### **East Anglia One North (EA1N) and East Anglia Two (EA2) Offshore Wind Farms**

**Planning Inspectorate Reference: EA1N – EN010077 & EA2 – EN010078**

**Deadline 5 - 3 February 2021**

**East Suffolk Council's Summary of Oral Case - Issue Specific Hearing 6**

| East Anglia TWO Offshore Wind Farm | | | Drg No | EA2-DEV-DRG-IBR-000693 | |

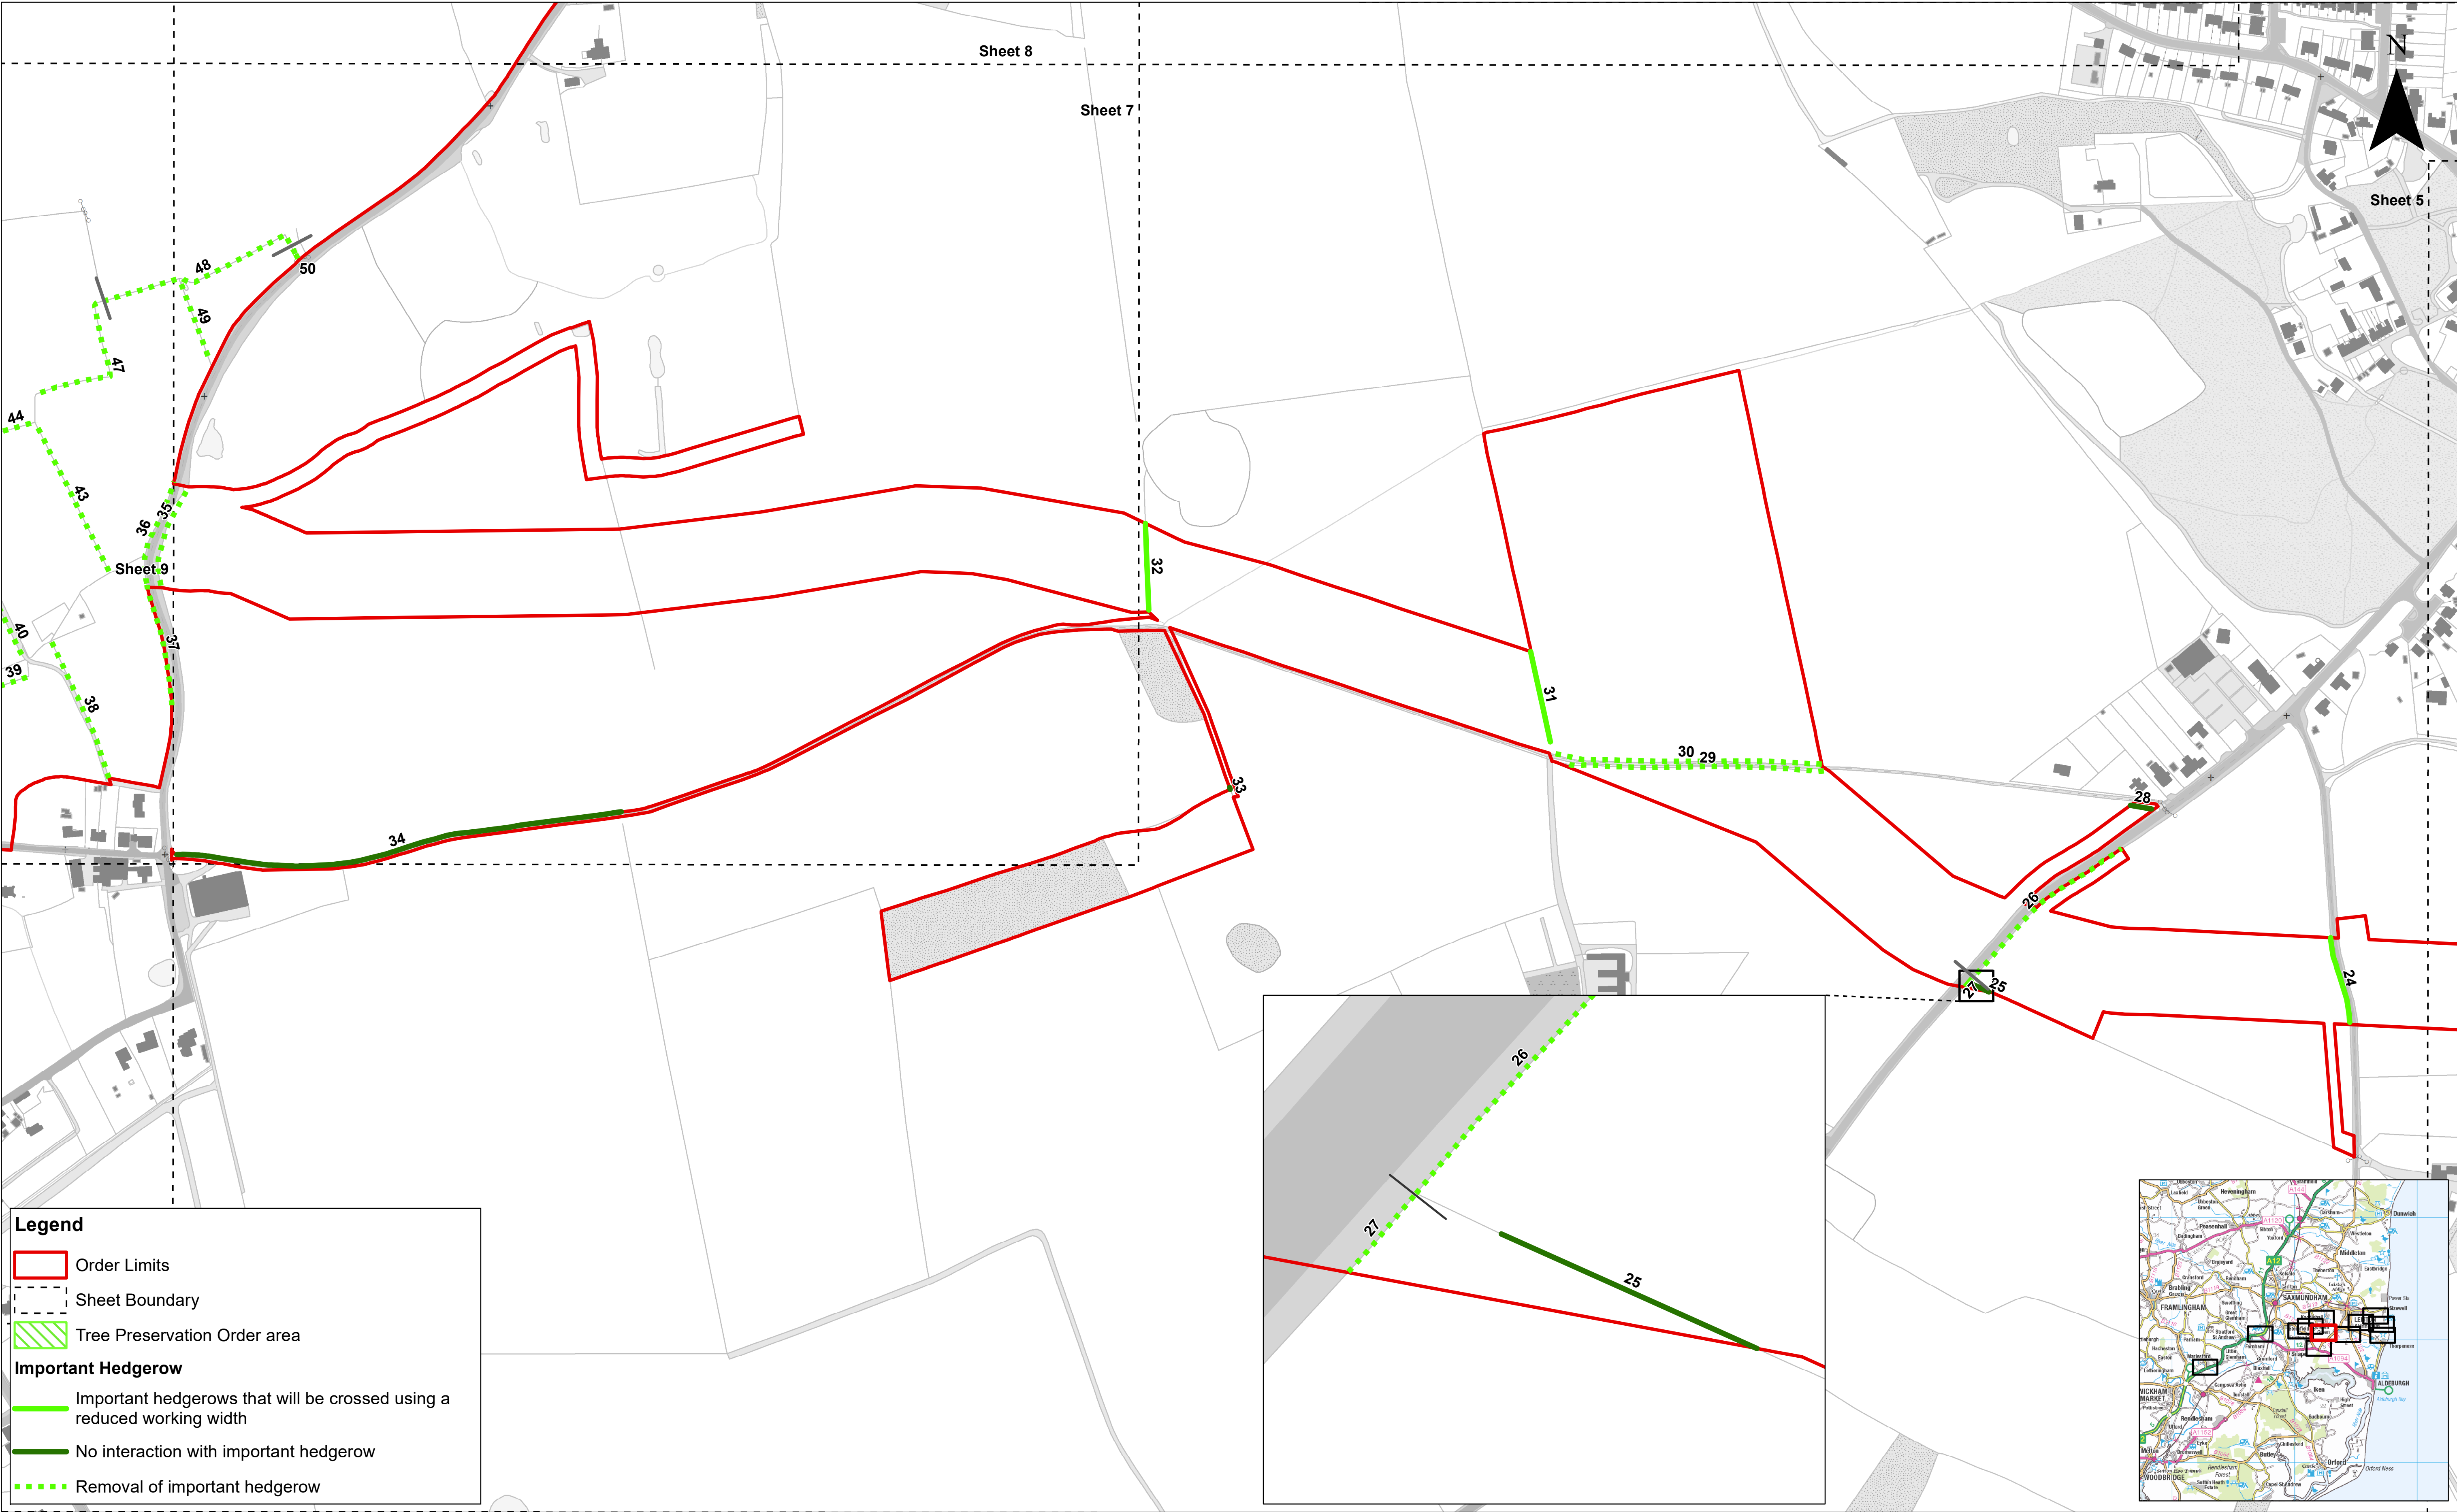
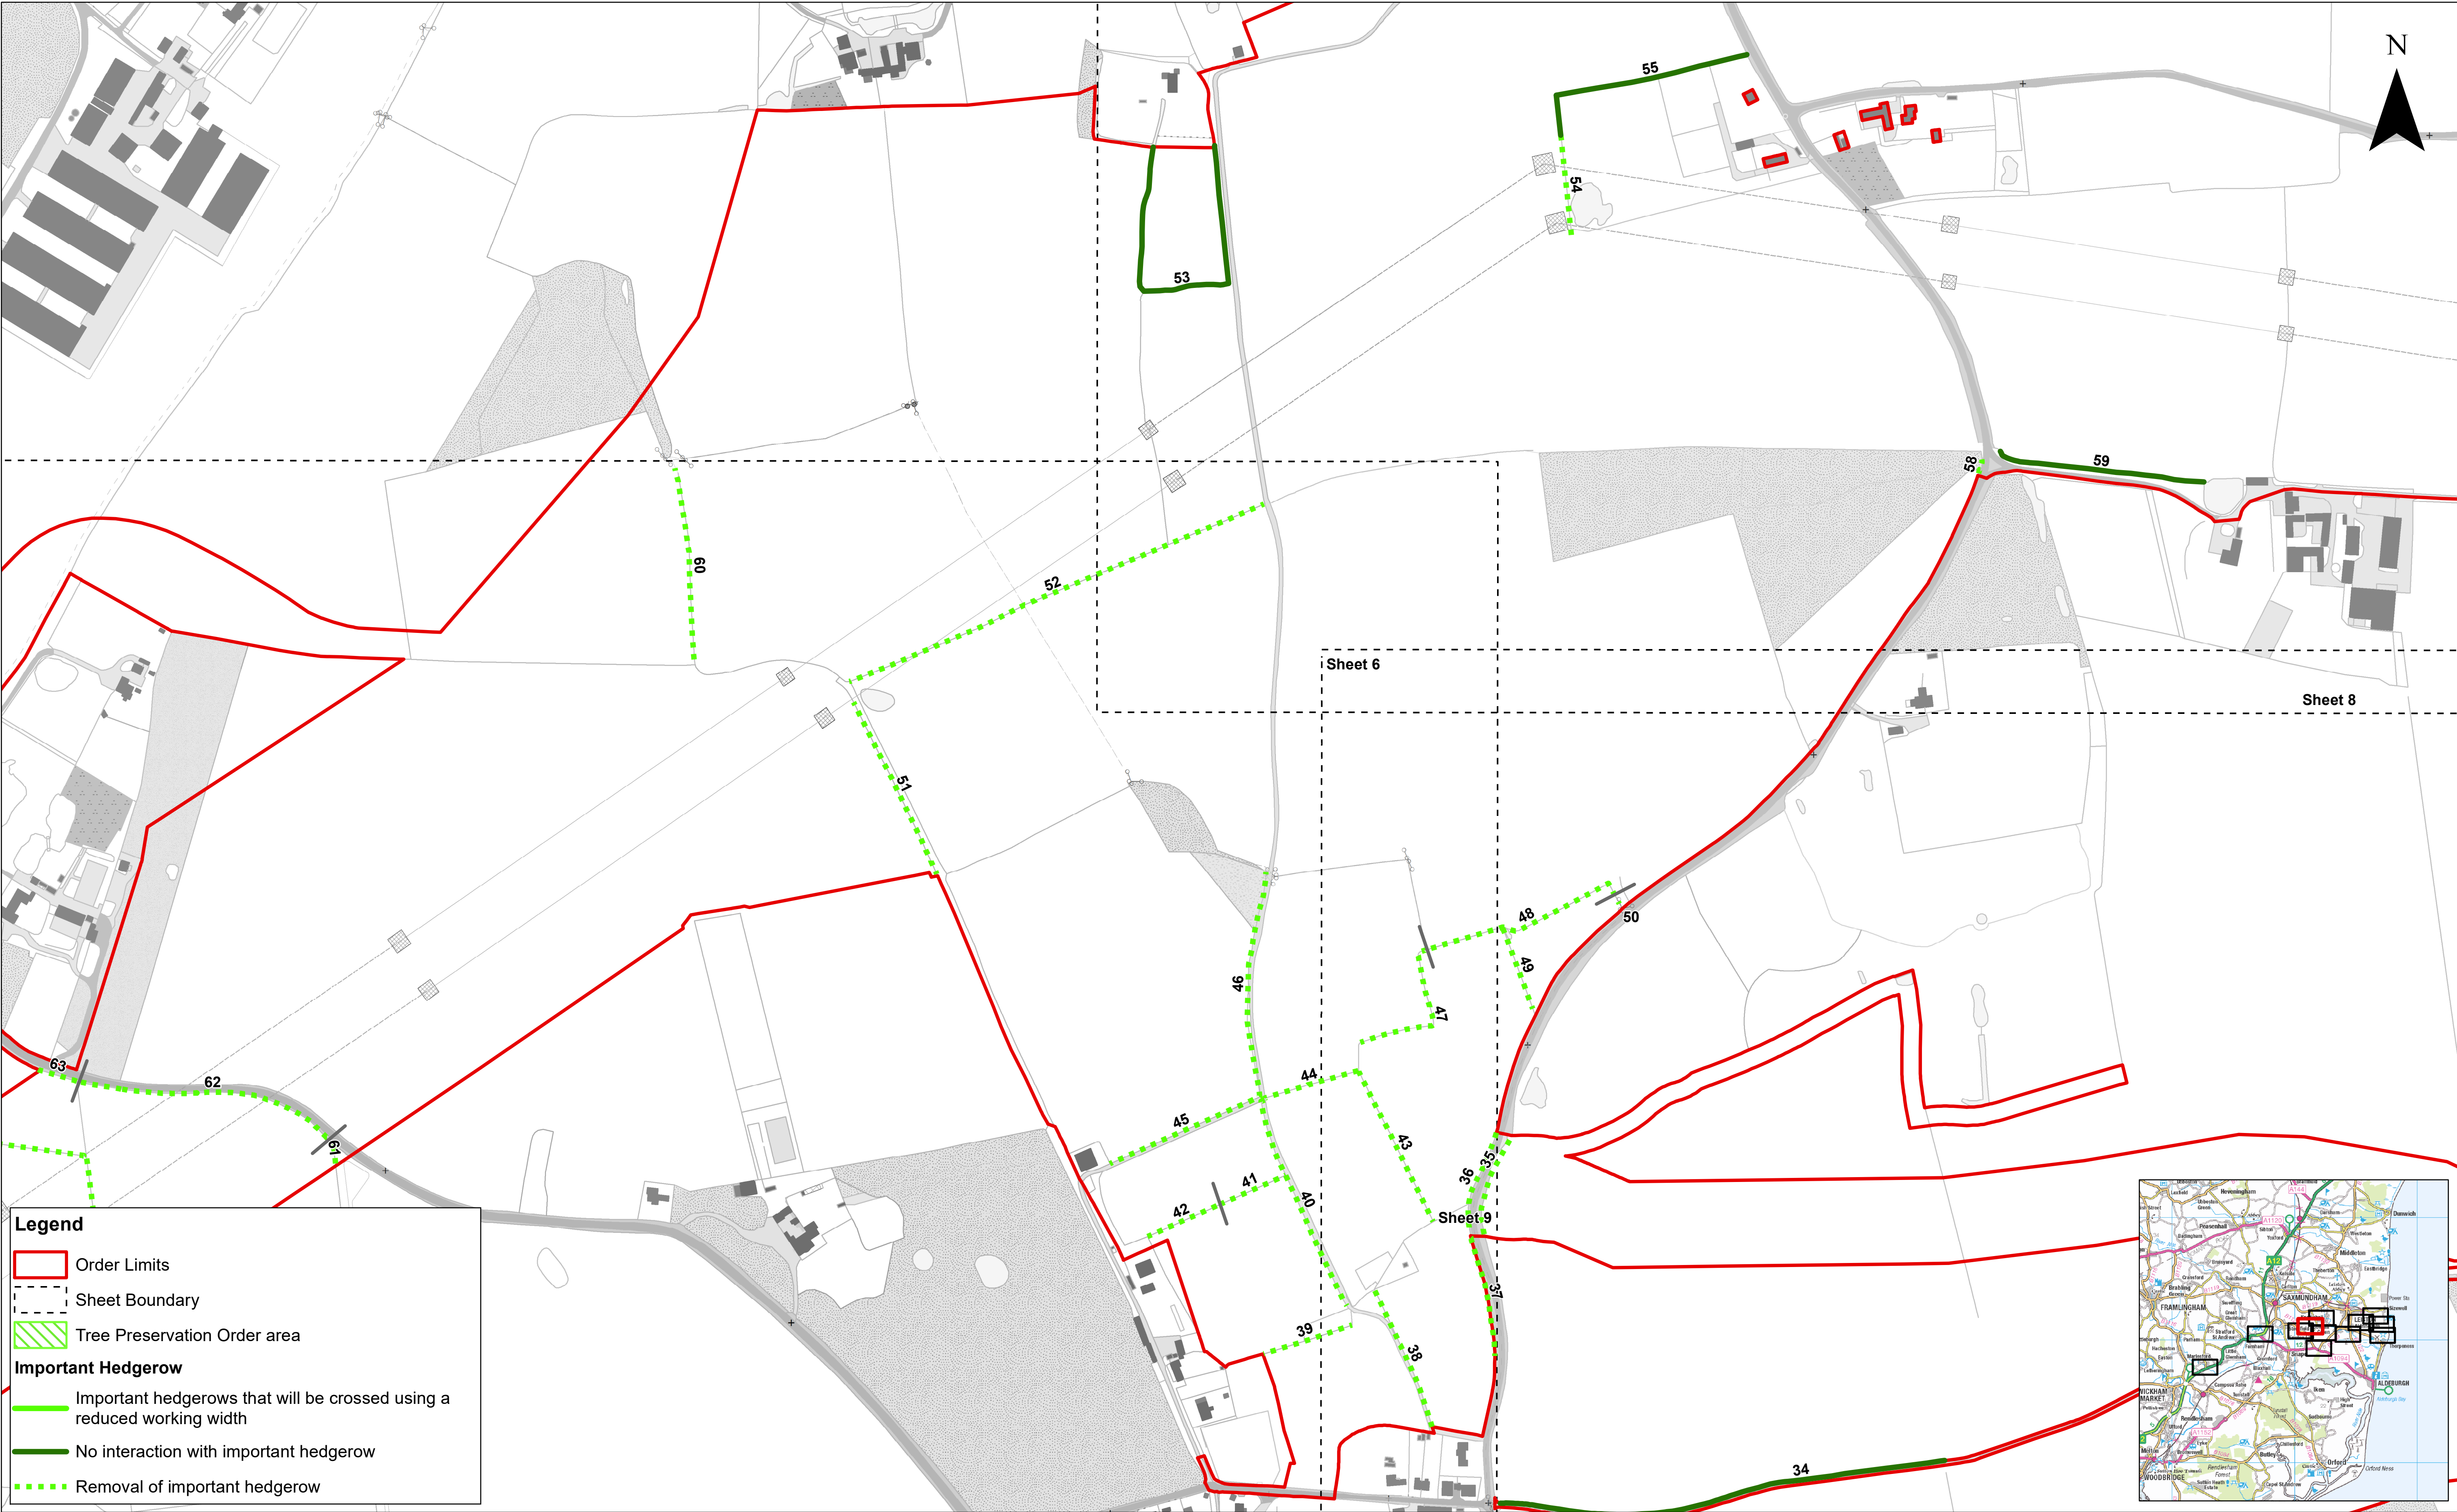
ESC supports SCC and the Applicants submissions in relation to the MoU. It is considered that a requirement is not necessary and could restrict the flexibility and dynamism which the MoU in its current form allows.
Schedule 11 – Hedgerows Part 1 – Removal of Important Hedgerows		<p>ESC seeks clarity regarding the hedgerows identified with Schedule 11 of the draft DCOs.</p> <p>ESC seeks clarity regarding the hedgerows identified within Schedule 11 of the draft DCOs.</p> <p>Hedgerows marked 1 and 2 are identified within Schedule 11 (REP3-011) as being removed but on the Important Hedgerows and Tree Preservation Order Plan (REP3-010) they are identified as being crossed with a reduced width. Annex 1 of the OLEMS document (REP3-030) identifies hedgerows 1 and 2 as being subject to full or partial removal. Clarification on this is required.</p> <p>Clarification is also required in relation to hedgerow marked 28 which is identified on the Important Hedgerows and Tree Preservation Order Plan (REP3-010) as being removed but is not identified within Schedule 11 as being removed and identified in Annex 1 of the OLEMS (REP3-030) as not subject to interaction.</p> <p>The interaction identified within Annex 1 of the OLEMS (REP3-030) in relation to a number of hedgerows does not appear to correspond to the interaction identified within Schedule 11 of the draft DCOs (REP3-011) and the interaction identified on the Important Hedgerows and Tree Preservation Order Plan (REP3-010). Further clarification as to the reasons for this is required. Does Annex 1 identify a greater</p>

number of important hedgerows to be crossed with a reduced width as some of these will be crossed with a width less than 32m but greater than the draft DCOs definition of reduced width which is 16.1m?
<p>Schedule 16 – Procedure for discharge of requirements</p> <p>1 – Applications made for certain approvals</p> <p>2 – Further information</p>		<p>ESC understands that this procedure is set out in Appendix 1 of The Planning Inspectorate's 15: Drafting Development Consent Orders but there have been a number of recent DCOs which have been granted with wording which varies from that set out. ESC is particularly referring to the two latest decisions on offshore windfarms published relating to Hornsea Project Three and Norfolk Vanguard Offshore Wind Farms.</p> <p>Schedule 16 does not include any details in relation to the information the Applicant should provide. For example, the Norfolk Vanguard DCO included the wording:</p> <p><i>"a) the undertaker must give the discharging authority sufficient information to identify the requirement(s) to which the application relates;</i></p> <p><i>"b) the undertaker must provide such particulars, and the request be accompanied by such plans and drawings, as are reasonably considered necessary to deal with the application."</i></p> <p>The Council considers that this would be useful additional wording.</p> <p>1(2)(a) ESC considers that 42 days provides an insufficient standard time period in which to discharge requirements. It is noted that this is the timescale set out in Appendix 1, however a longer period of 56 days is provided when discharging planning application conditions and therefore a shorter period is not considered appropriate. The DCOs and requirements relate to multiple large scale complex developments which will require significant resource from ESC and consultation with</p>
